August 30, 2013

Subject: Approval, Cliff Island Septic System Association, Cliff Island, Cumberland

The Division of Environmental Health has completed a review of a design for an engineered subsurface sewage disposal system design, to serve Cliff Island Septic System Association. The HHE-200 Form dated 09/27/12 was prepared by Mark Hampton, S.E. The system was designed by Pinkham & Greer Consulting Engineers, with plans signed and stamped by you. The application was complete for processing on 08/08/13.

AREA OF WOODCHIP COVER
SCALE: 1"=50'

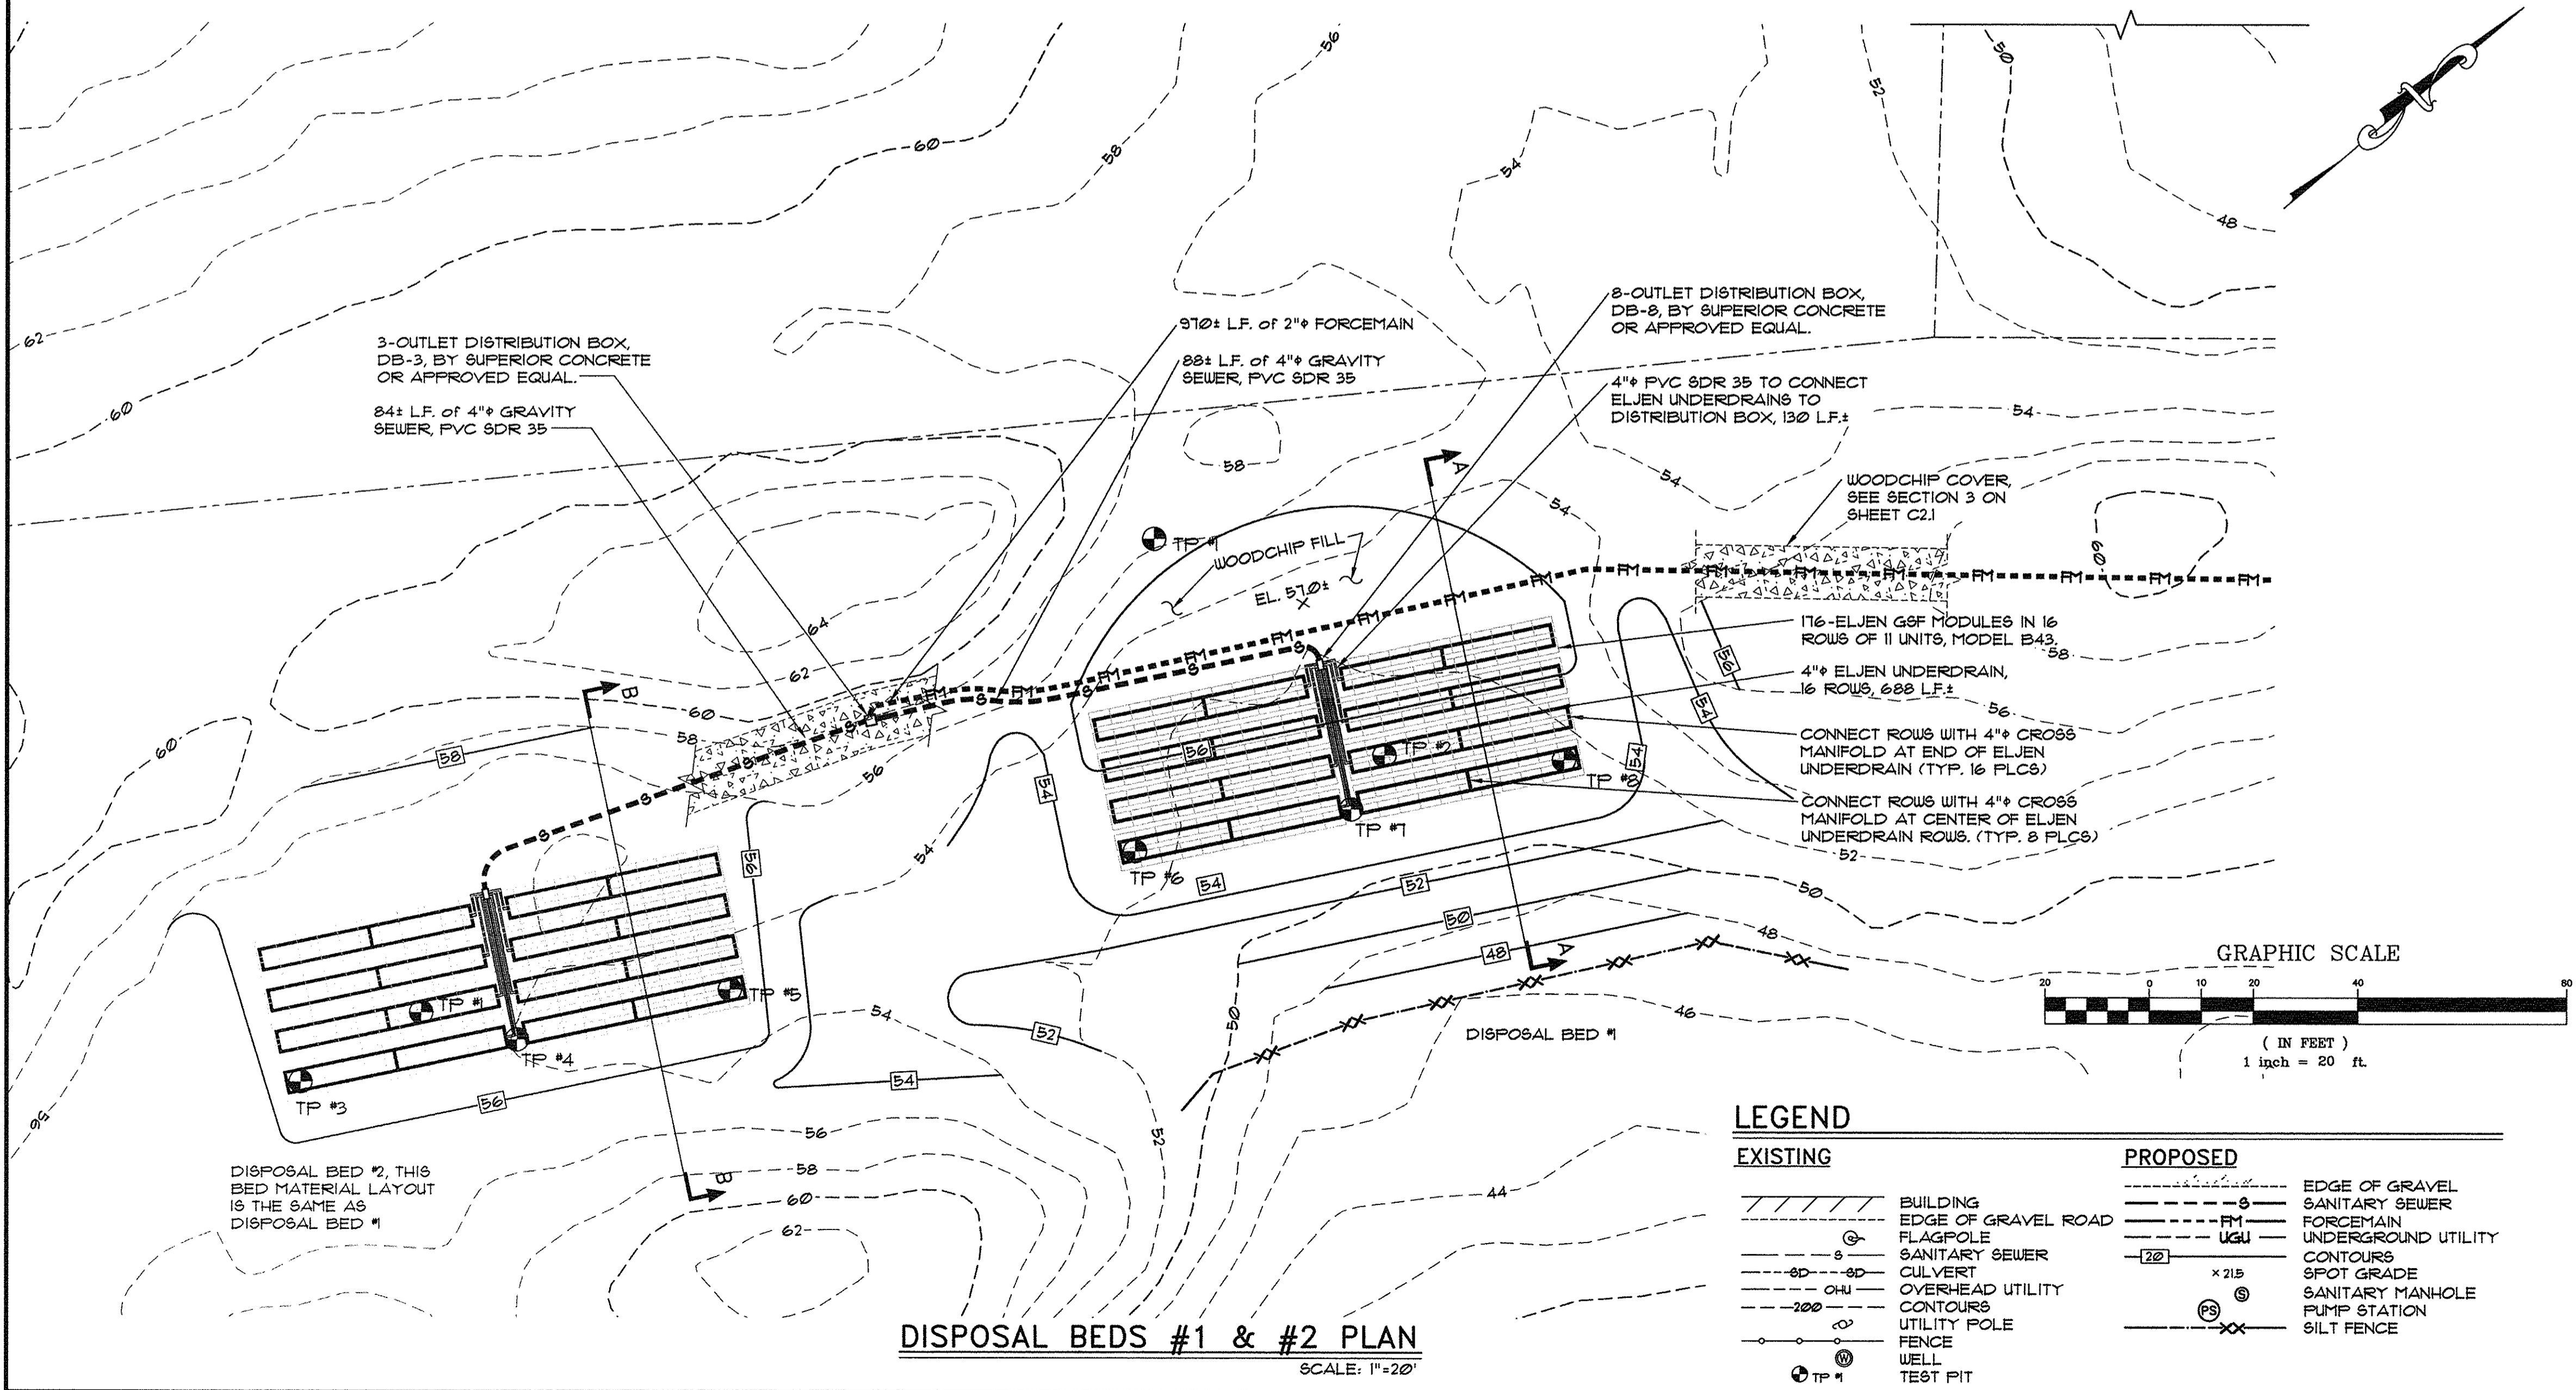
Transmissivity analysis predicts the possibility of effluent surfacing within 310 feet of disposal field #1, the reason for placing a 1-foot layer of woodchips down gradient of the disposal field. To ensure that the woodchip layer will function as intended, and to avoid a possible violation of 38 MRS §413 or other applicable statutes/regulations, the O&M manual should include a provision for periodic inspection and maintenance of the woodchip area. In addition, the O&M manual should include protocols for groundwater monitoring, as was recommended by the mounding and transmission analysis report.

The nearest wetlands are located approximately 260 feet to the southeast of the proposed engineered disposal fields. It is not anticipated that wetlands will be adversely impacted or altered from installation of the engineered disposal system, provided that appropriate erosion control measures are employed during system construction to minimize any risk, and provided the woodchip layer functions as intended, and is inspected and maintained periodically.
